Introduction

1. These comments provide feedback regarding certain elements of the project description, we wish to raise at this stage. A full review, once we have all the required documentation will be undertaken and presented as part of the DCO process going forward, if accepted by PINs.

N 	DRAWING NO. FIGURE 5.2.1g	REVISION For ES Issue
	DRAWN BY MS	PM / CHECKED BY KC

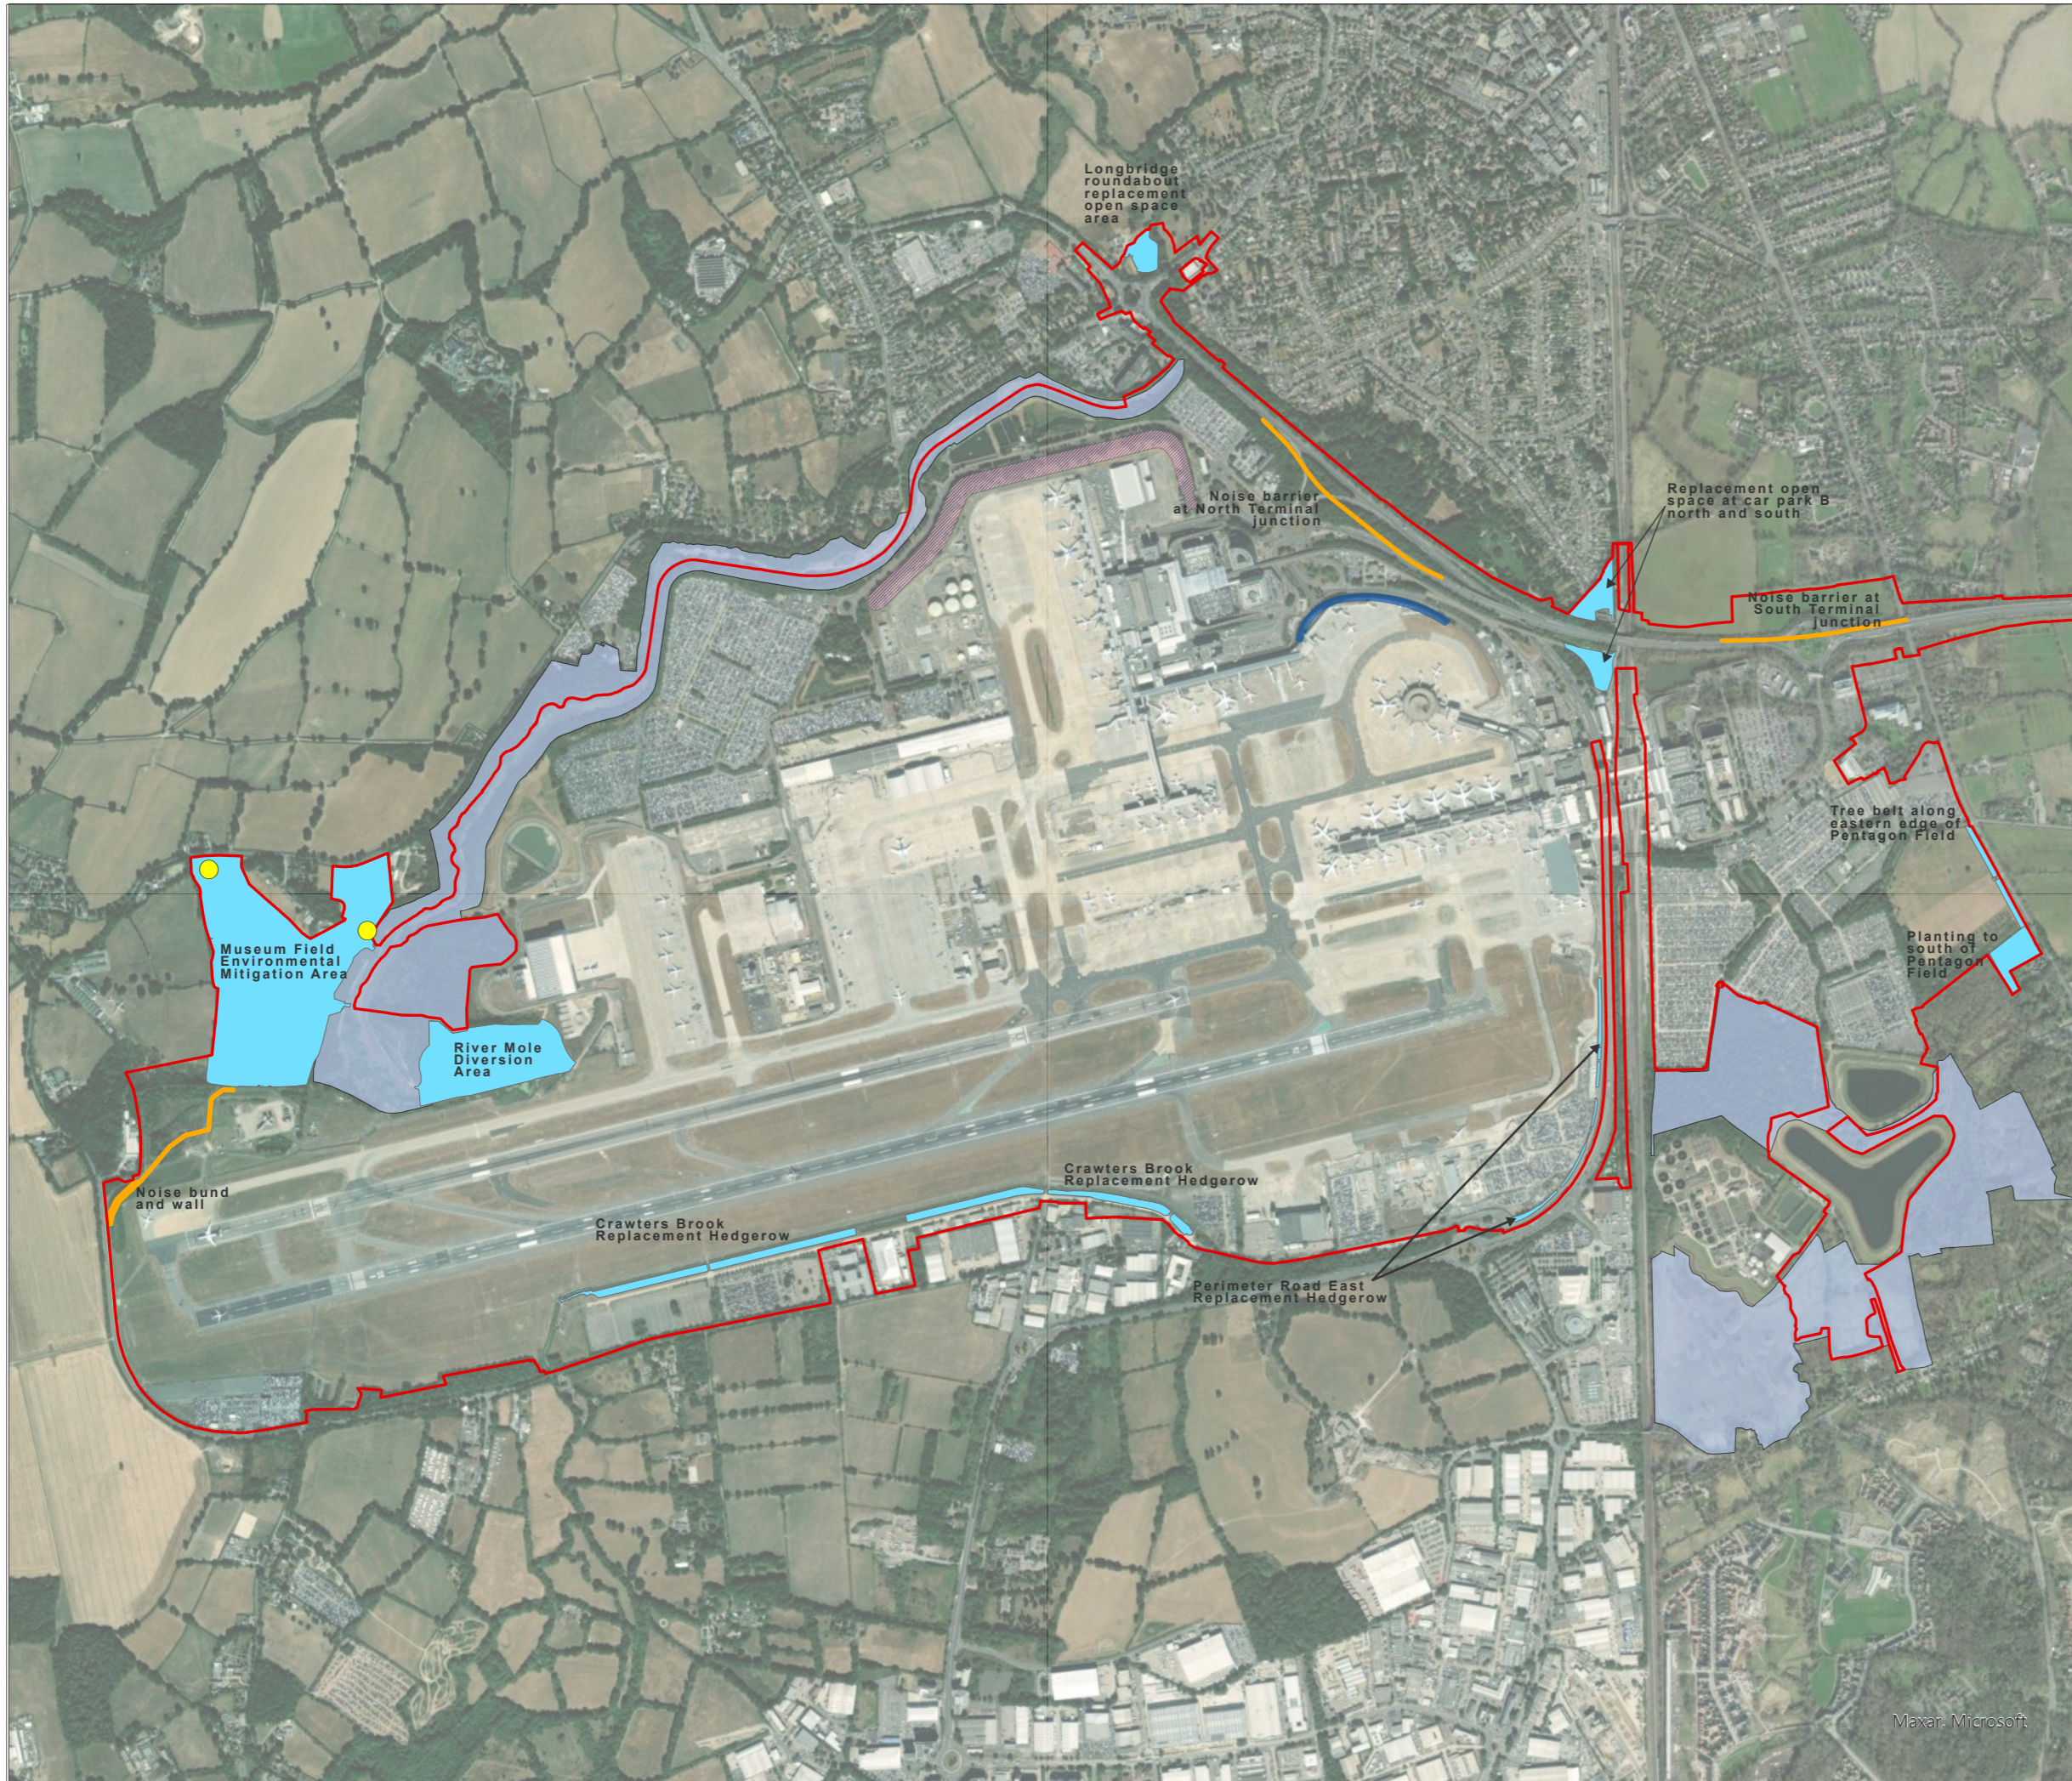
Figures	<p>ES Figure 5.2.1g Environmental mitigation and enhancement areas - The Gatwick Biodiversity Area is depicted in grey, a similar colour to the tarmac of roads, car parks and runways. An alternative colour would be preferable.</p>
Power strategy (5.2.119)	<p>Of particular importance is the exclusion of renewable energy generation initiatives and climate resilience. A major piece of the Council's work in delivery our climate change strategy will be around increasing awareness and knowledge around the impacts of climate change and beginning to prepare for those impacts to worsen over the next decades. WSCC would expect to see these elements factored into the design.</p>
West Sussex Fire and Rescue	<p>There are a number of comments from West Sussex Fire and Rescue regarding the design and potential effects upon emergency response times, some aspects are given below. A meeting to discuss these elements would be welcomed.</p>
